from
**Southern
Water**

Our ref
PLAN-037604

Proposal: Variation of condition 2-plans condition imposed under CM/21/19/PL to omit the detached garage serving units 5 and 6 and provide these two units with an attached garage allowing a sewer diversion to run between the units ensuring a 3m easement either side of the sewer in accordance with Southern Water requirements.

Site: CM/55/20/PL: - Scyld Horsemere, Green Lane, Climping, BN17 5QZ.

drawing information	title:	Site, Block & Location Plans
---------------------	--------	------------------------------

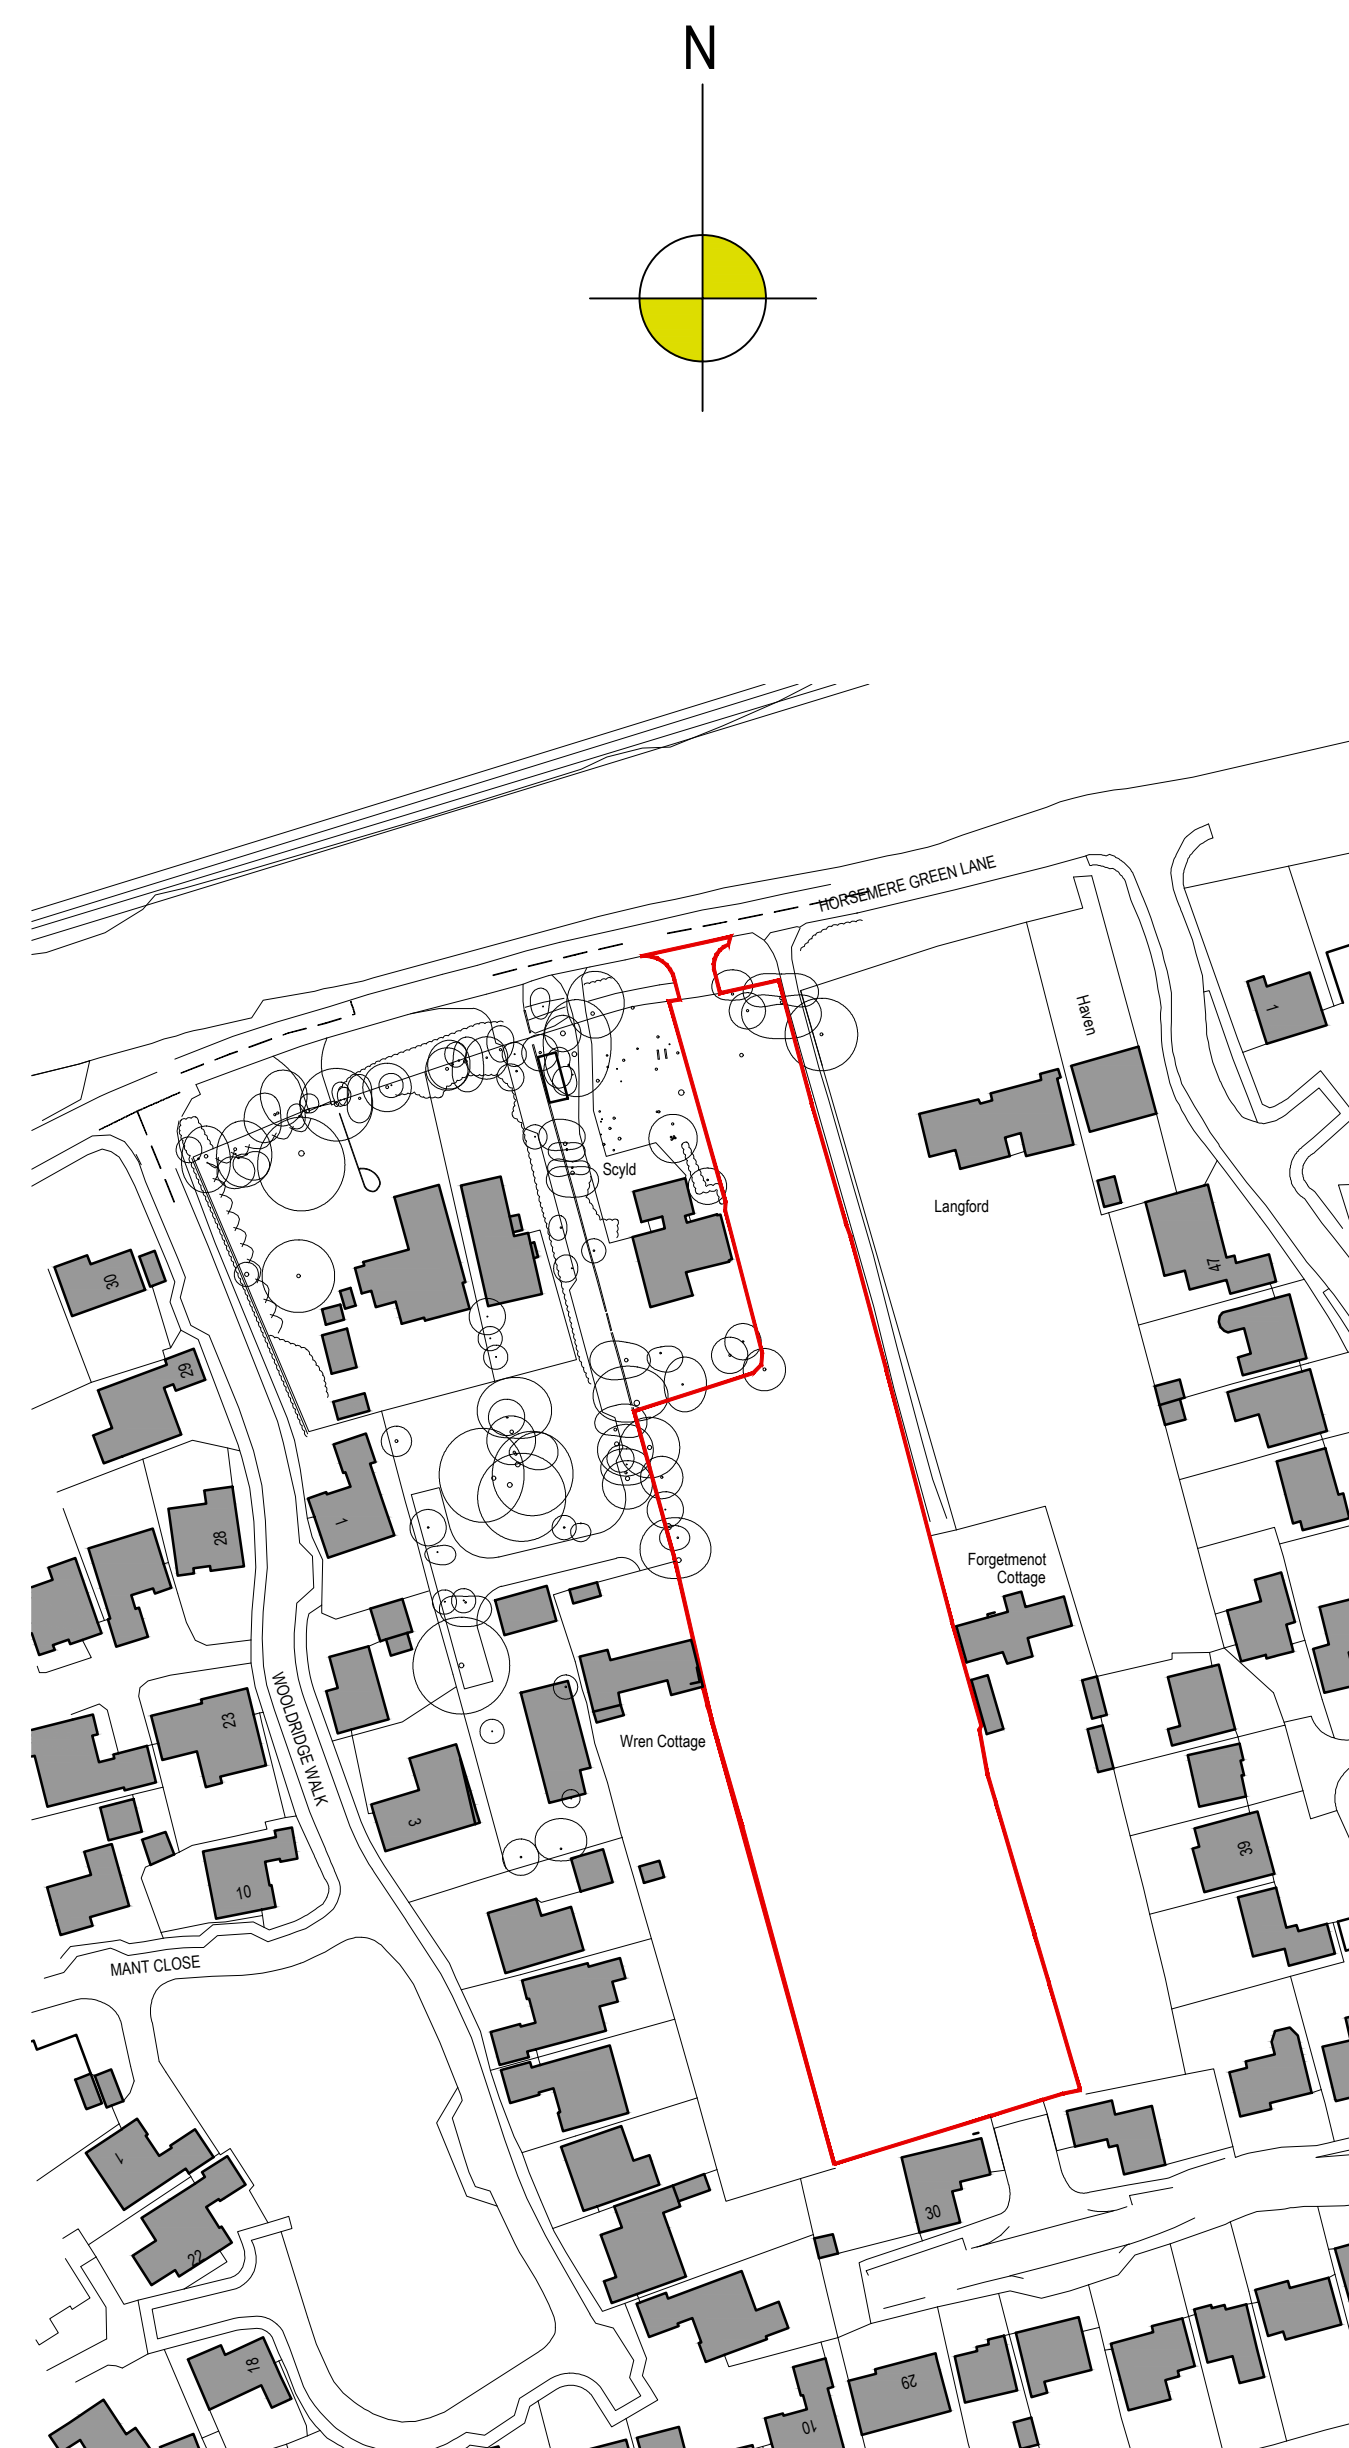
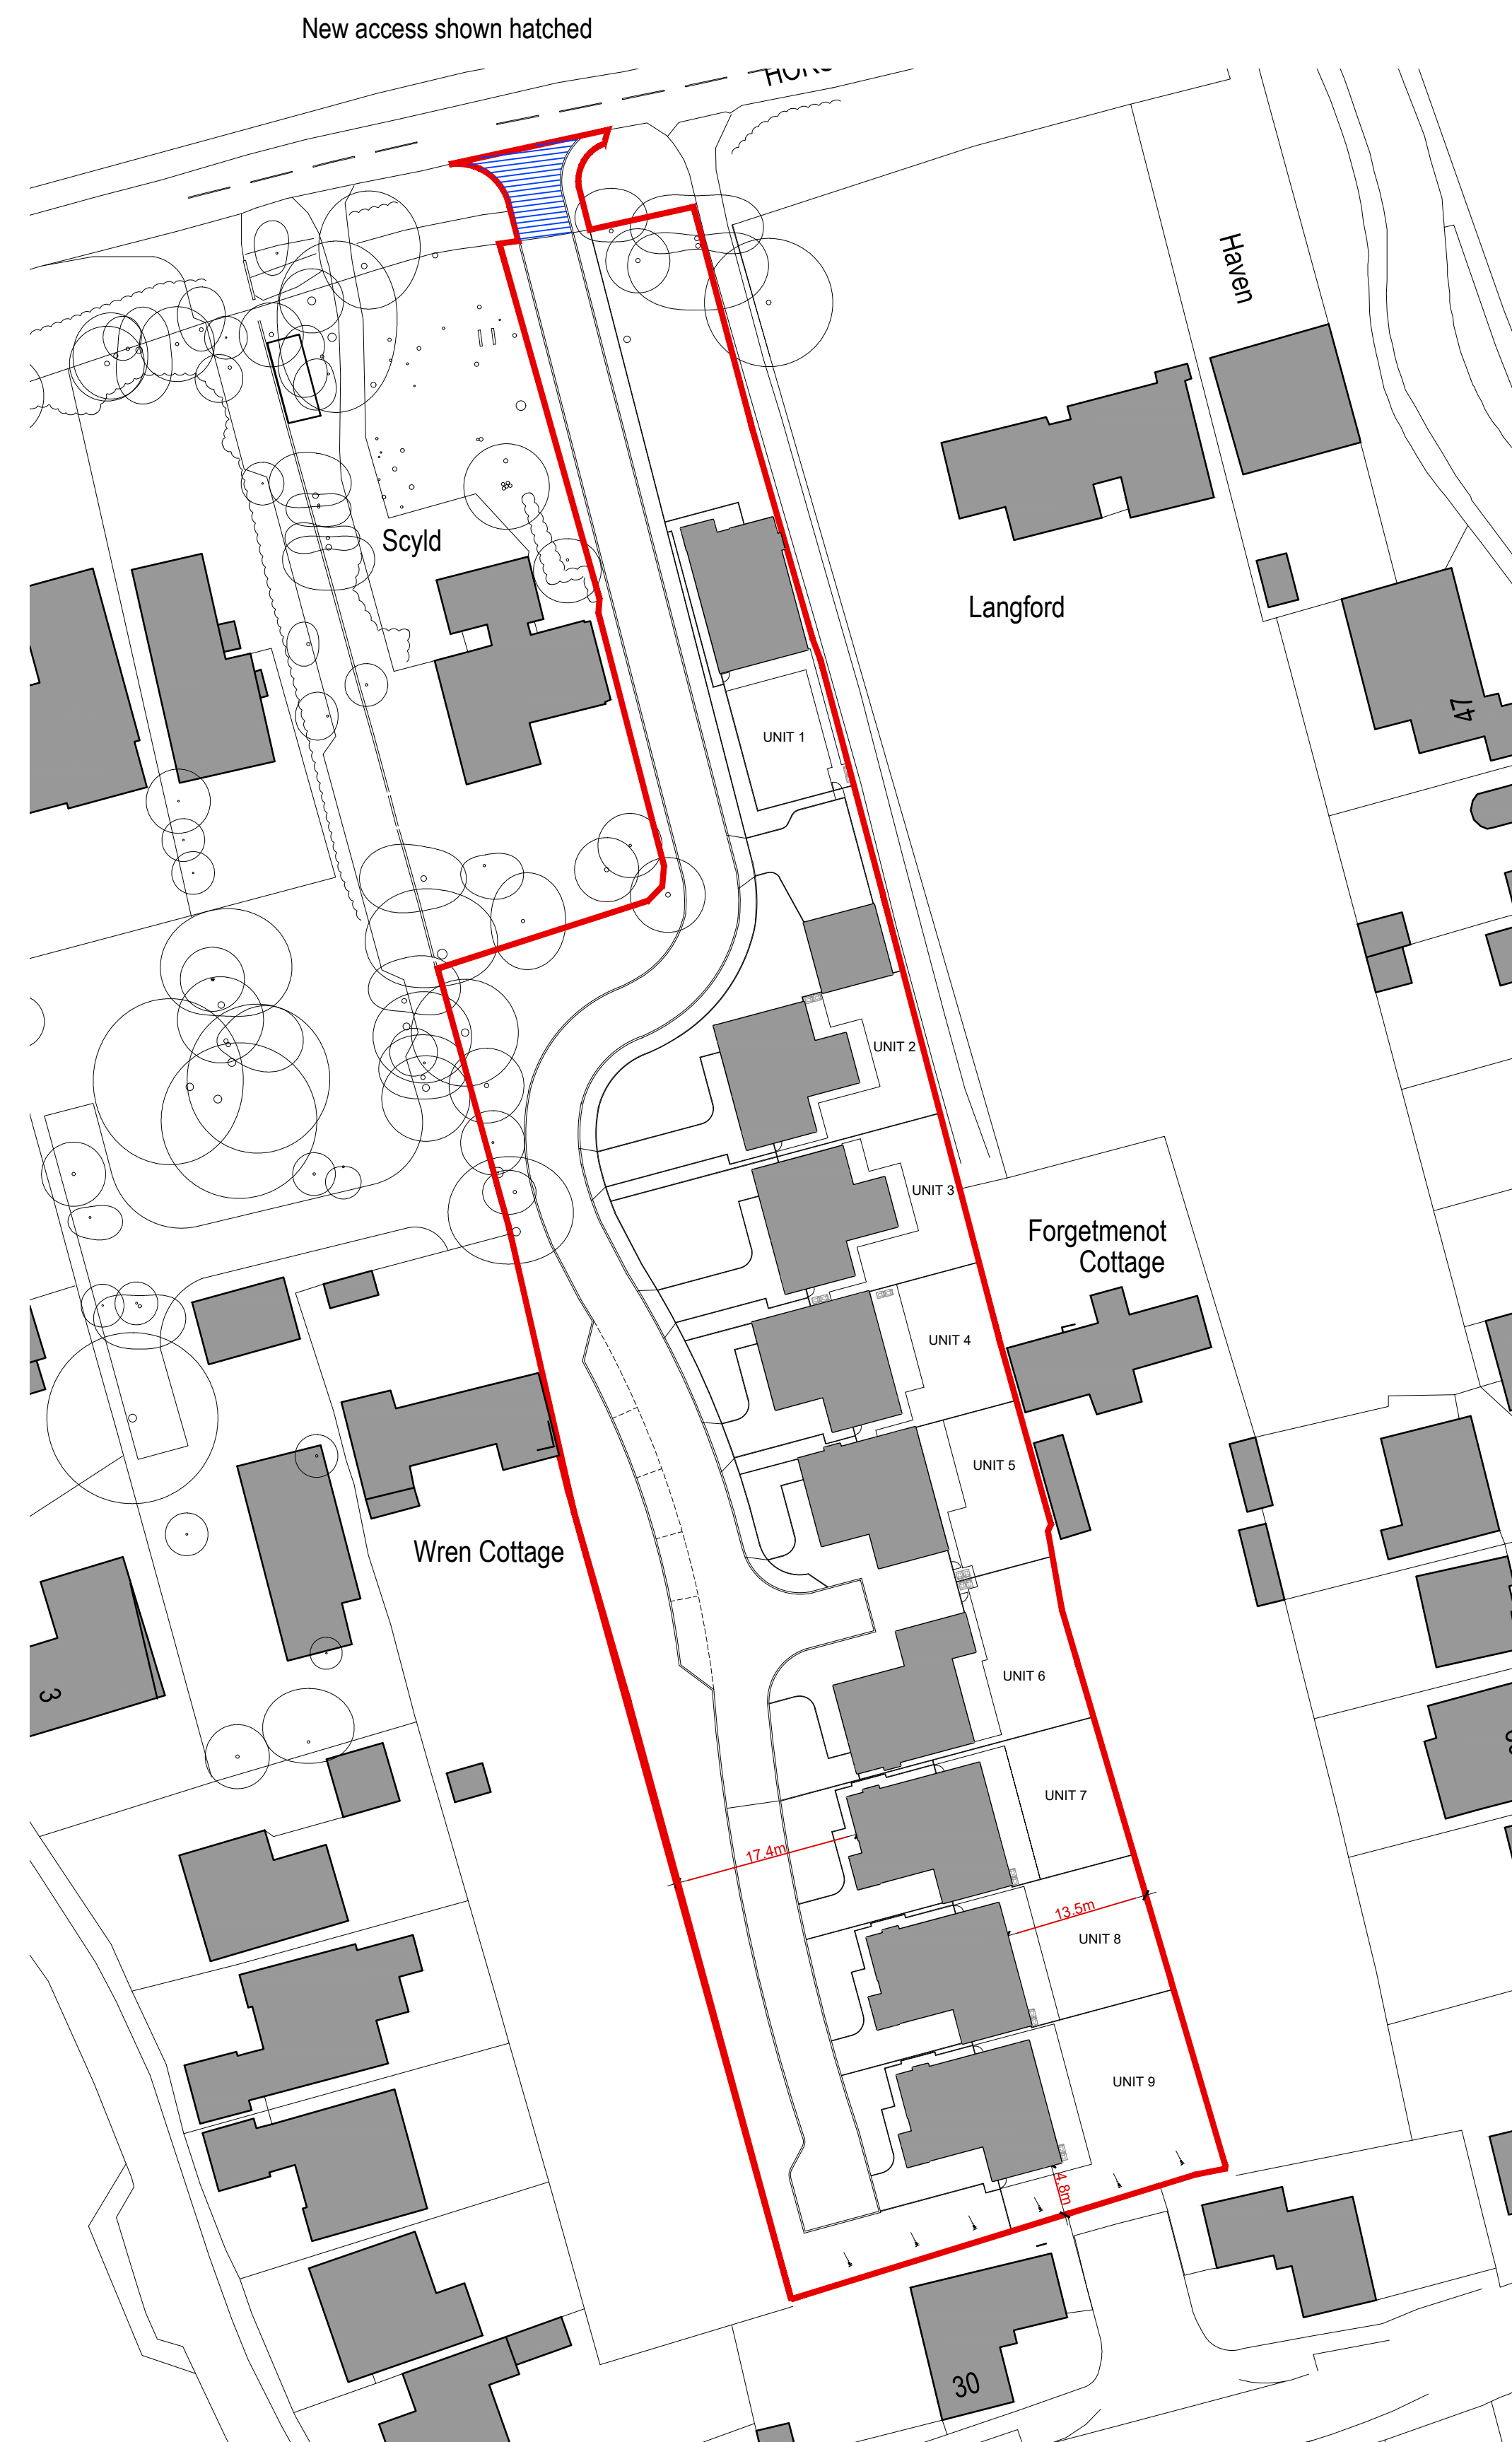
Southern Water does not recommend variation of condition 2 until the developer submits the detailed plan showing the 3 metres easement to the existing public foul sewer. Kindly submit a detailed plan, clearly indicating the 3 metres easement on either side of the public foul sewer.
